**CITY OF ALBUQUERQUE
PLANNING DEPARTMENT
June 2, 2010
DRB Comments**

PROJECT # 1008357

APPLICATION # 10-70143

RE: Tract A, Brentwood Park Complex

Amendment Site Development Plan

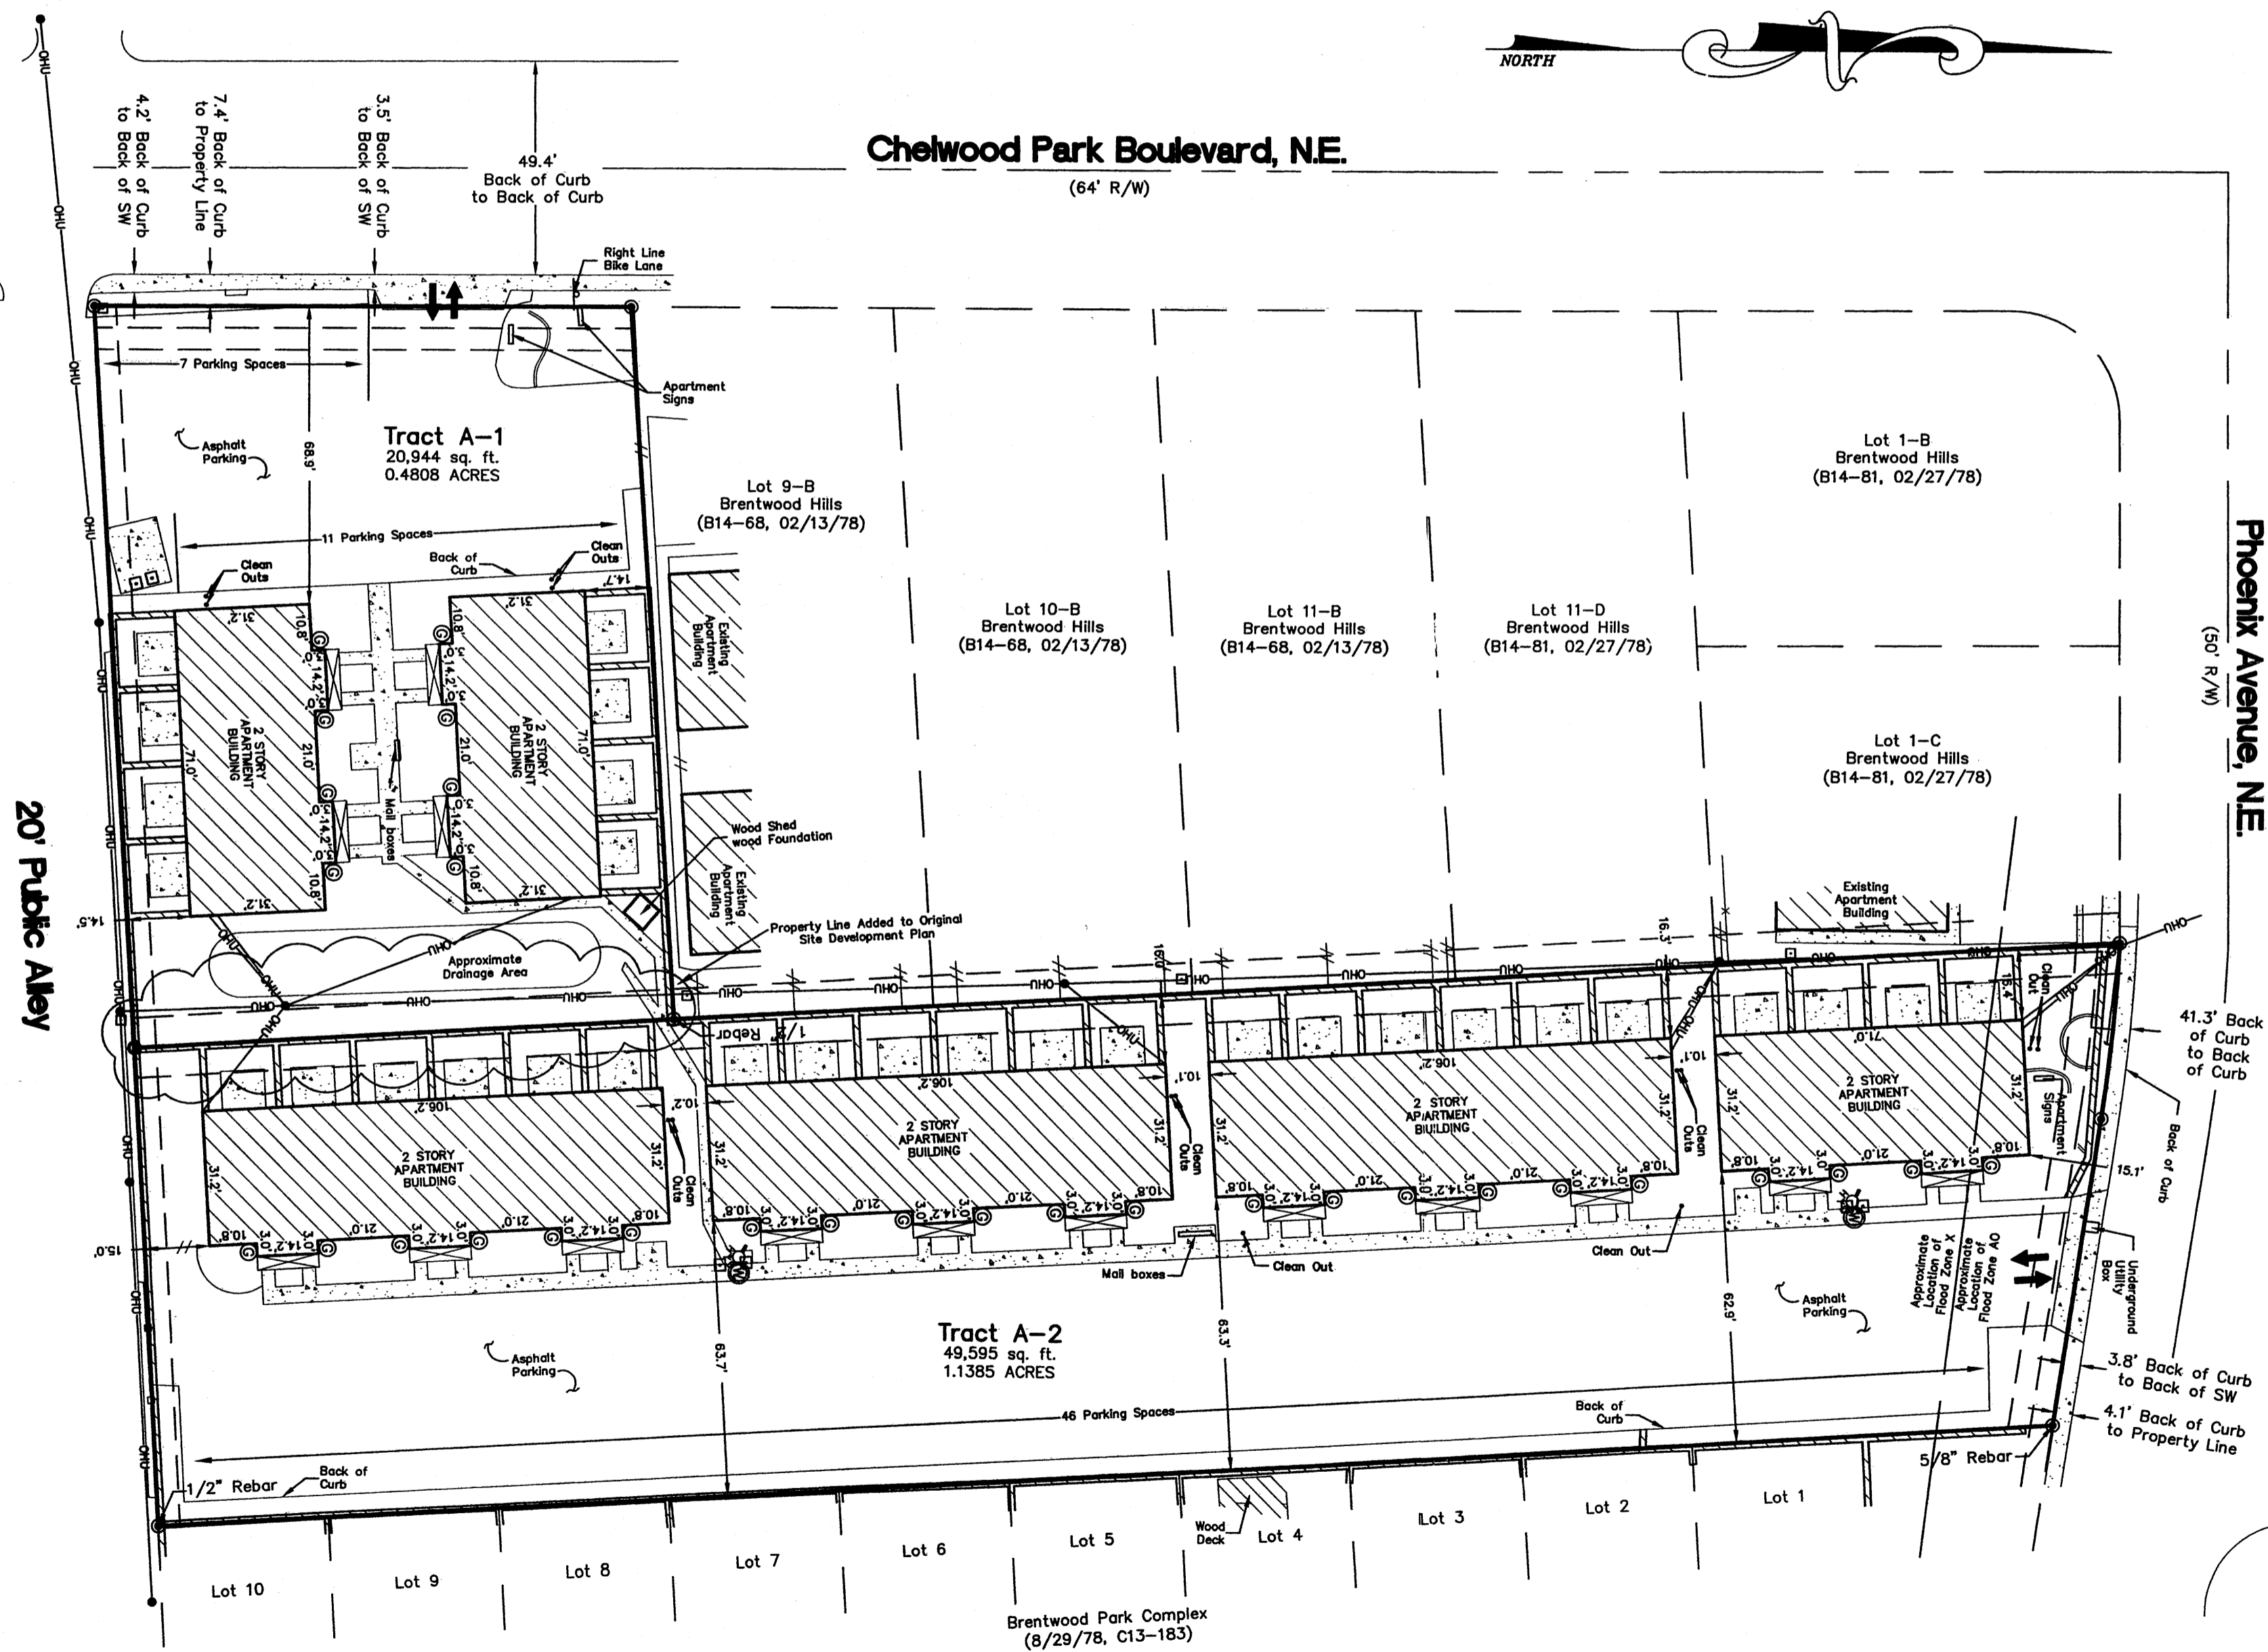
The zoning of this site is SU-1 which requires approval of a site development plan prior to platting [§ 14-14-2-2(B)(2) of the Subdivision Ordinance].

Plat of  
**Tracts A-1 and A-2**  
**Brentwood Park Complex**

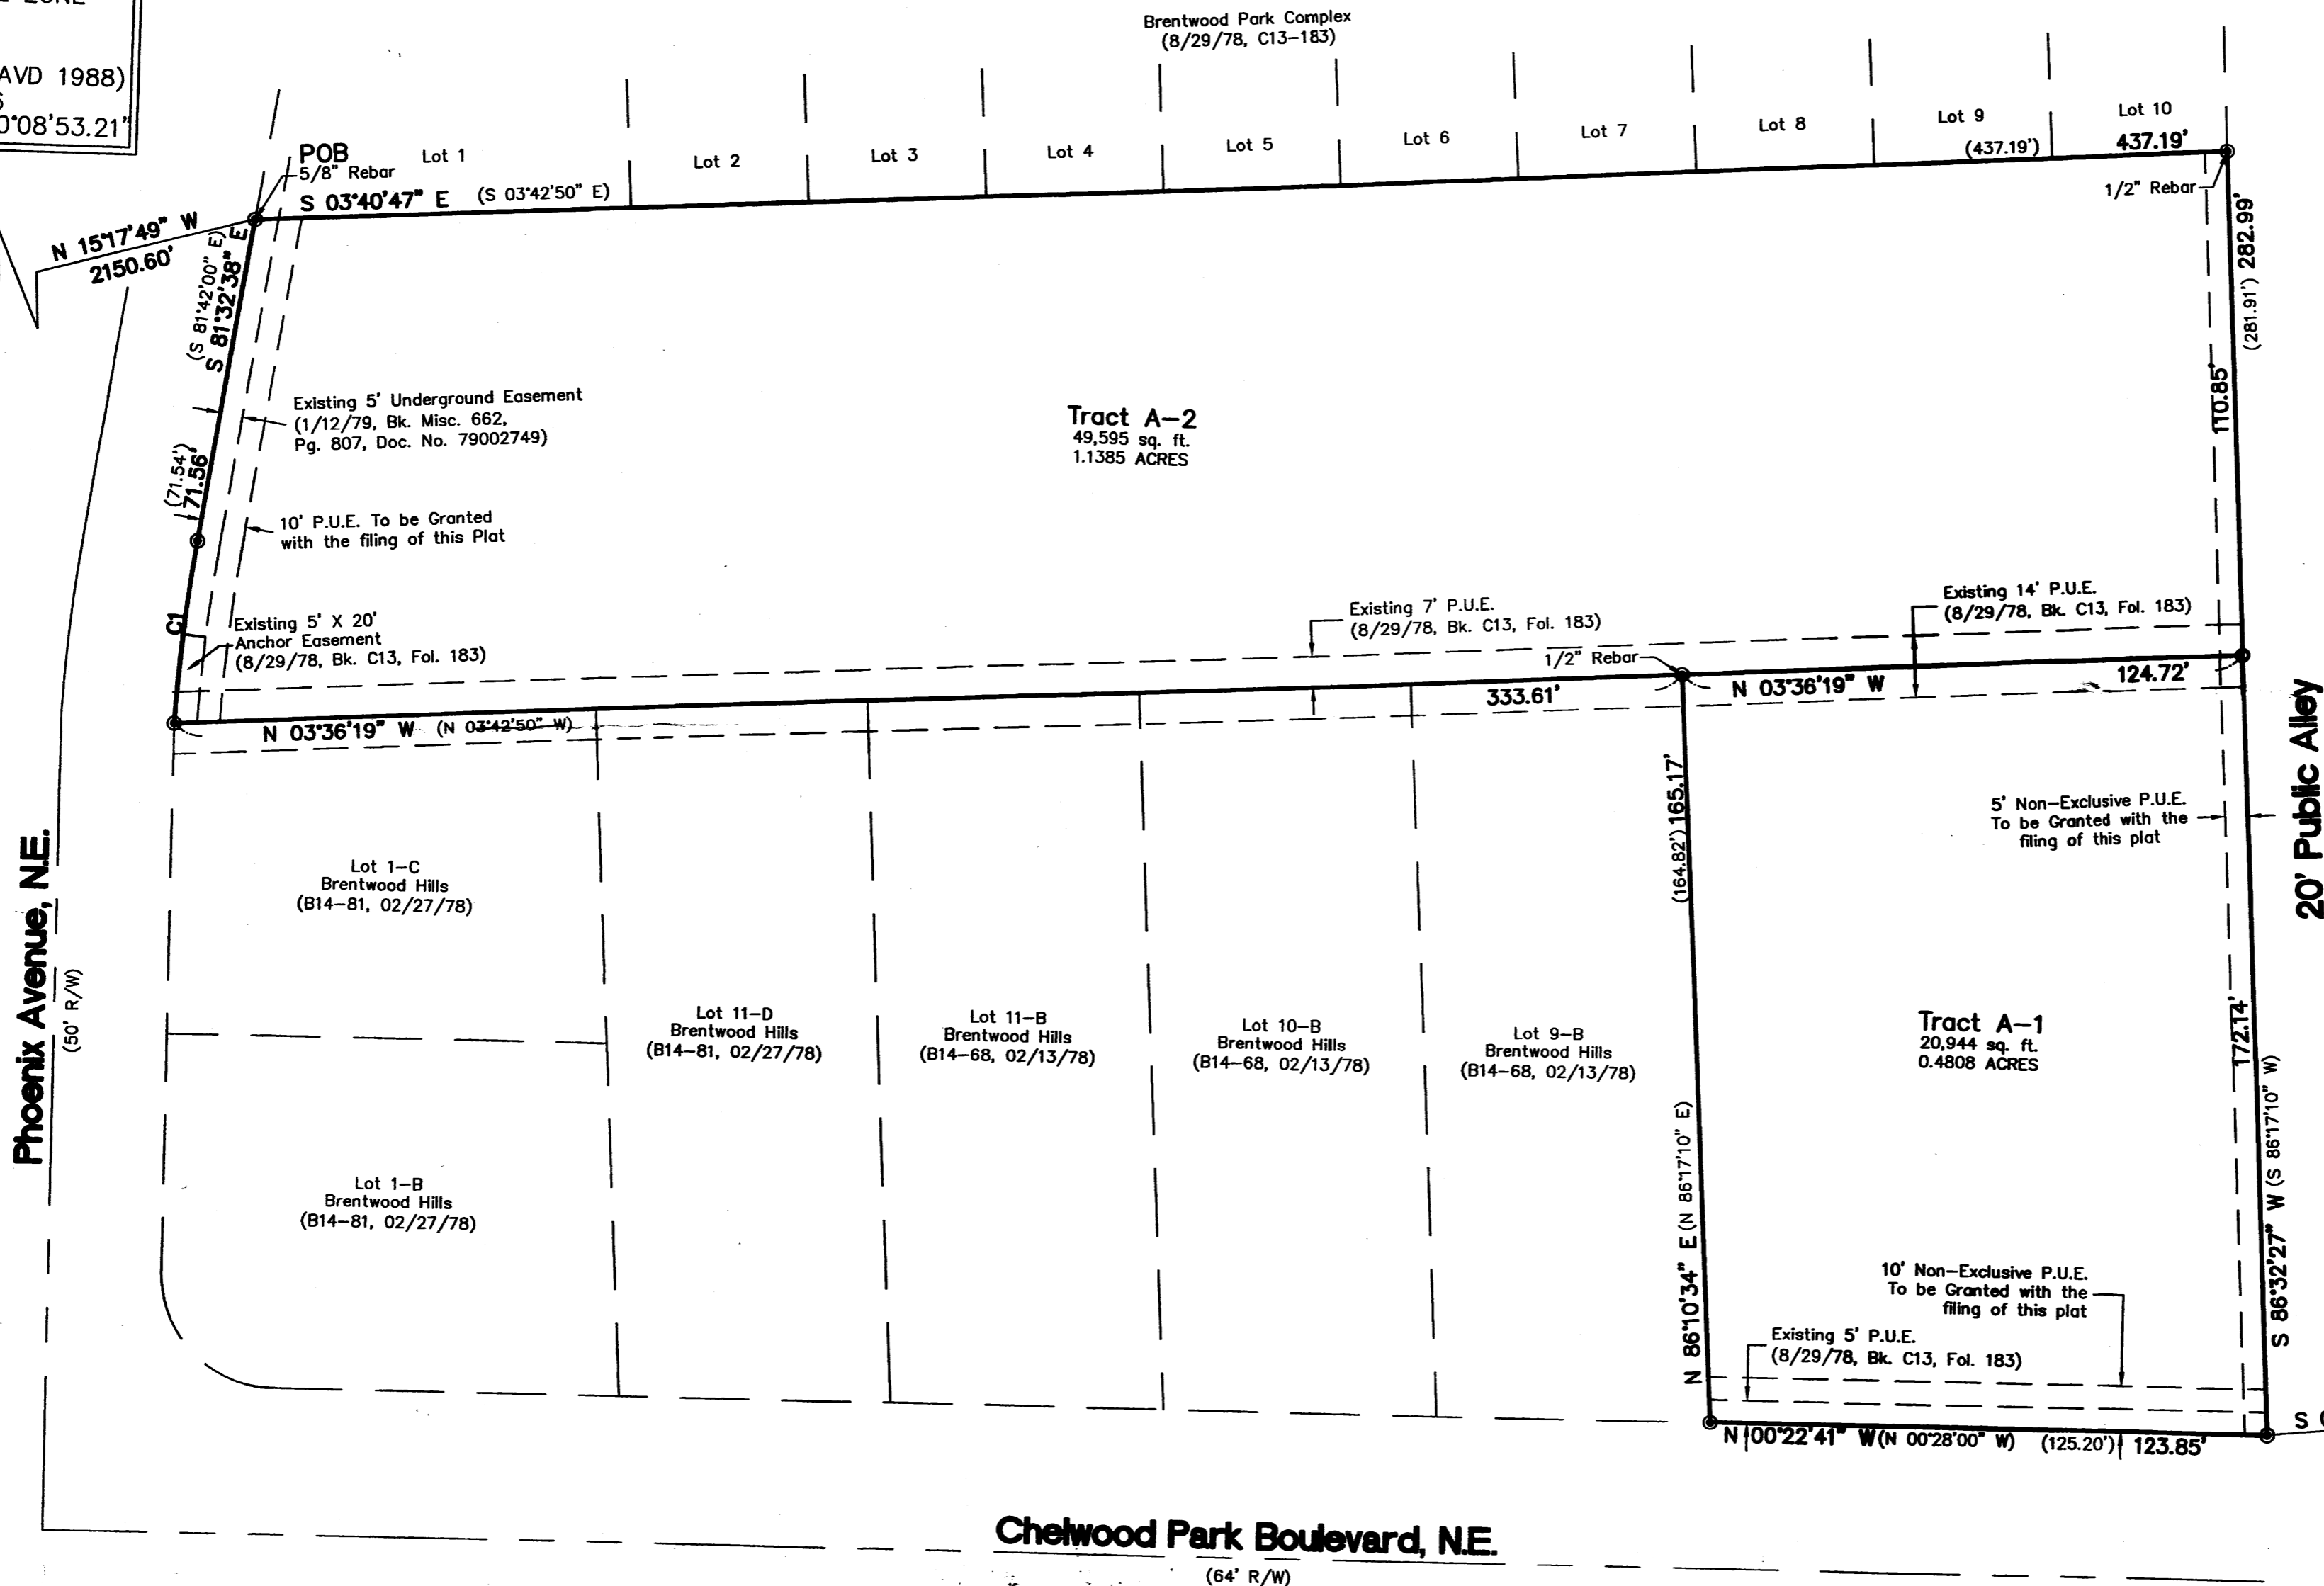
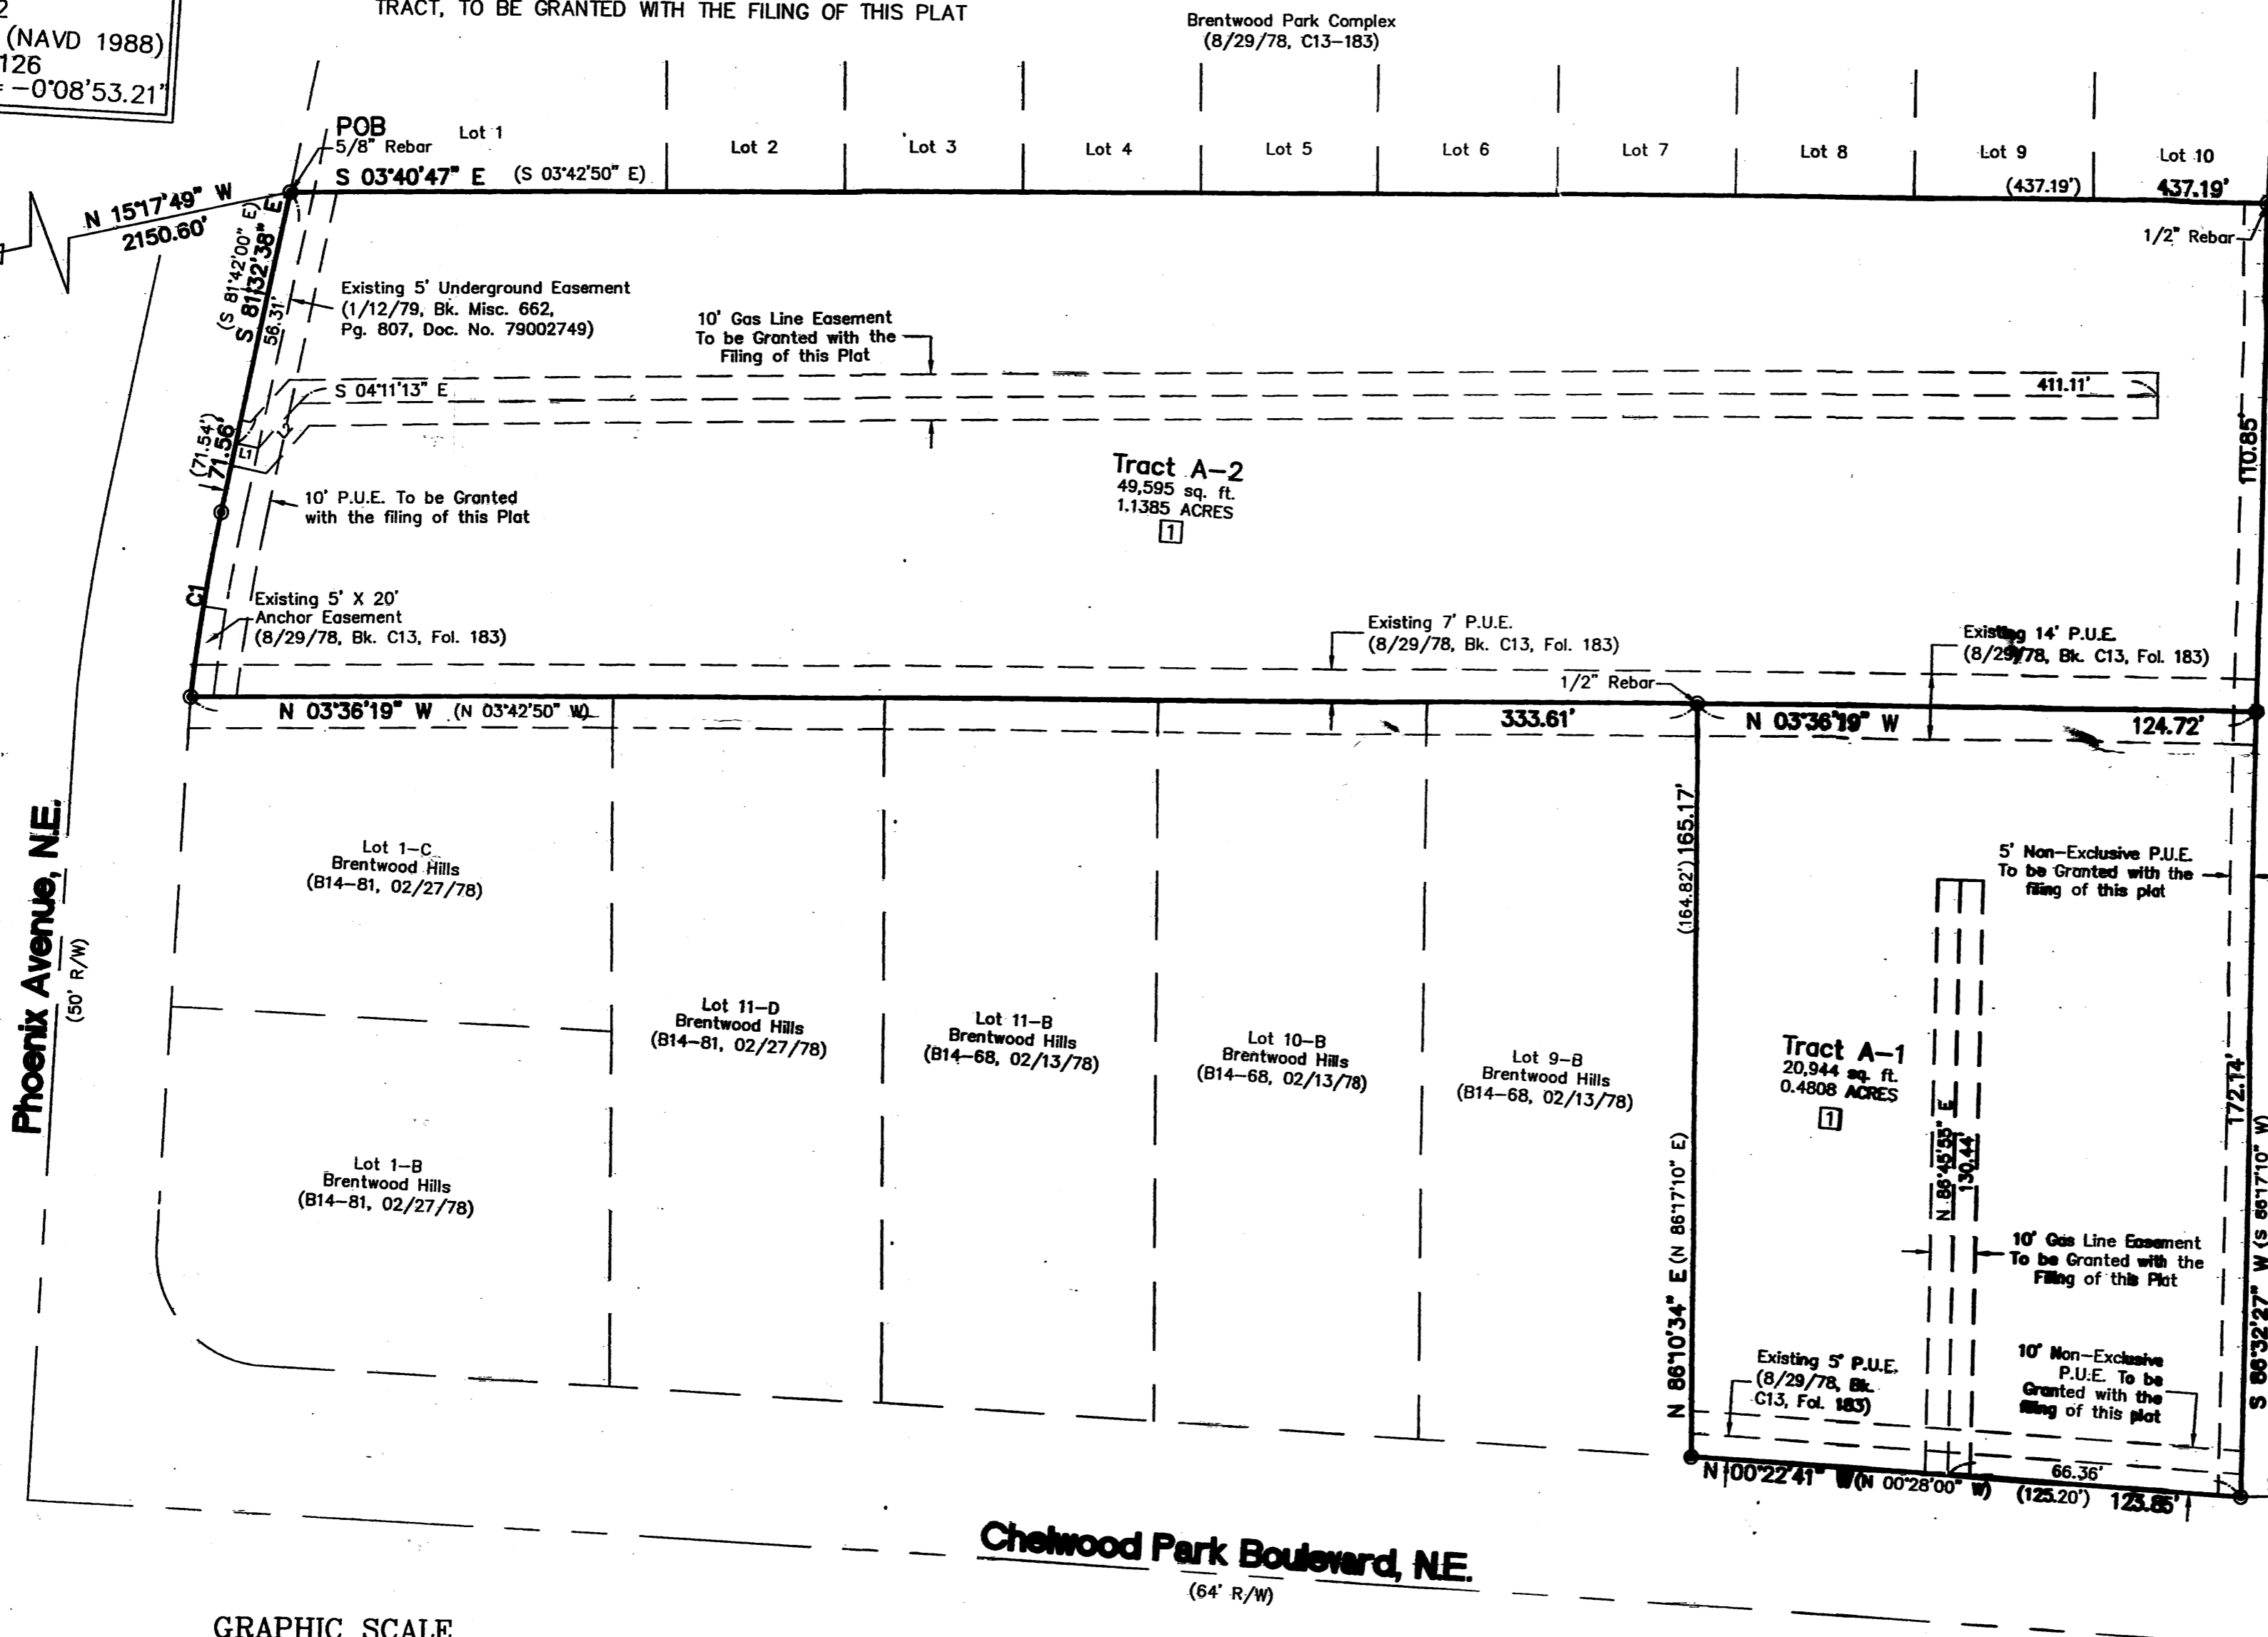
A Solar Note consistent with § 14-14-4-7 of the Subdivision Ordinance is required. Also, for future reference please remove "ZONING" from Subdivision Data.
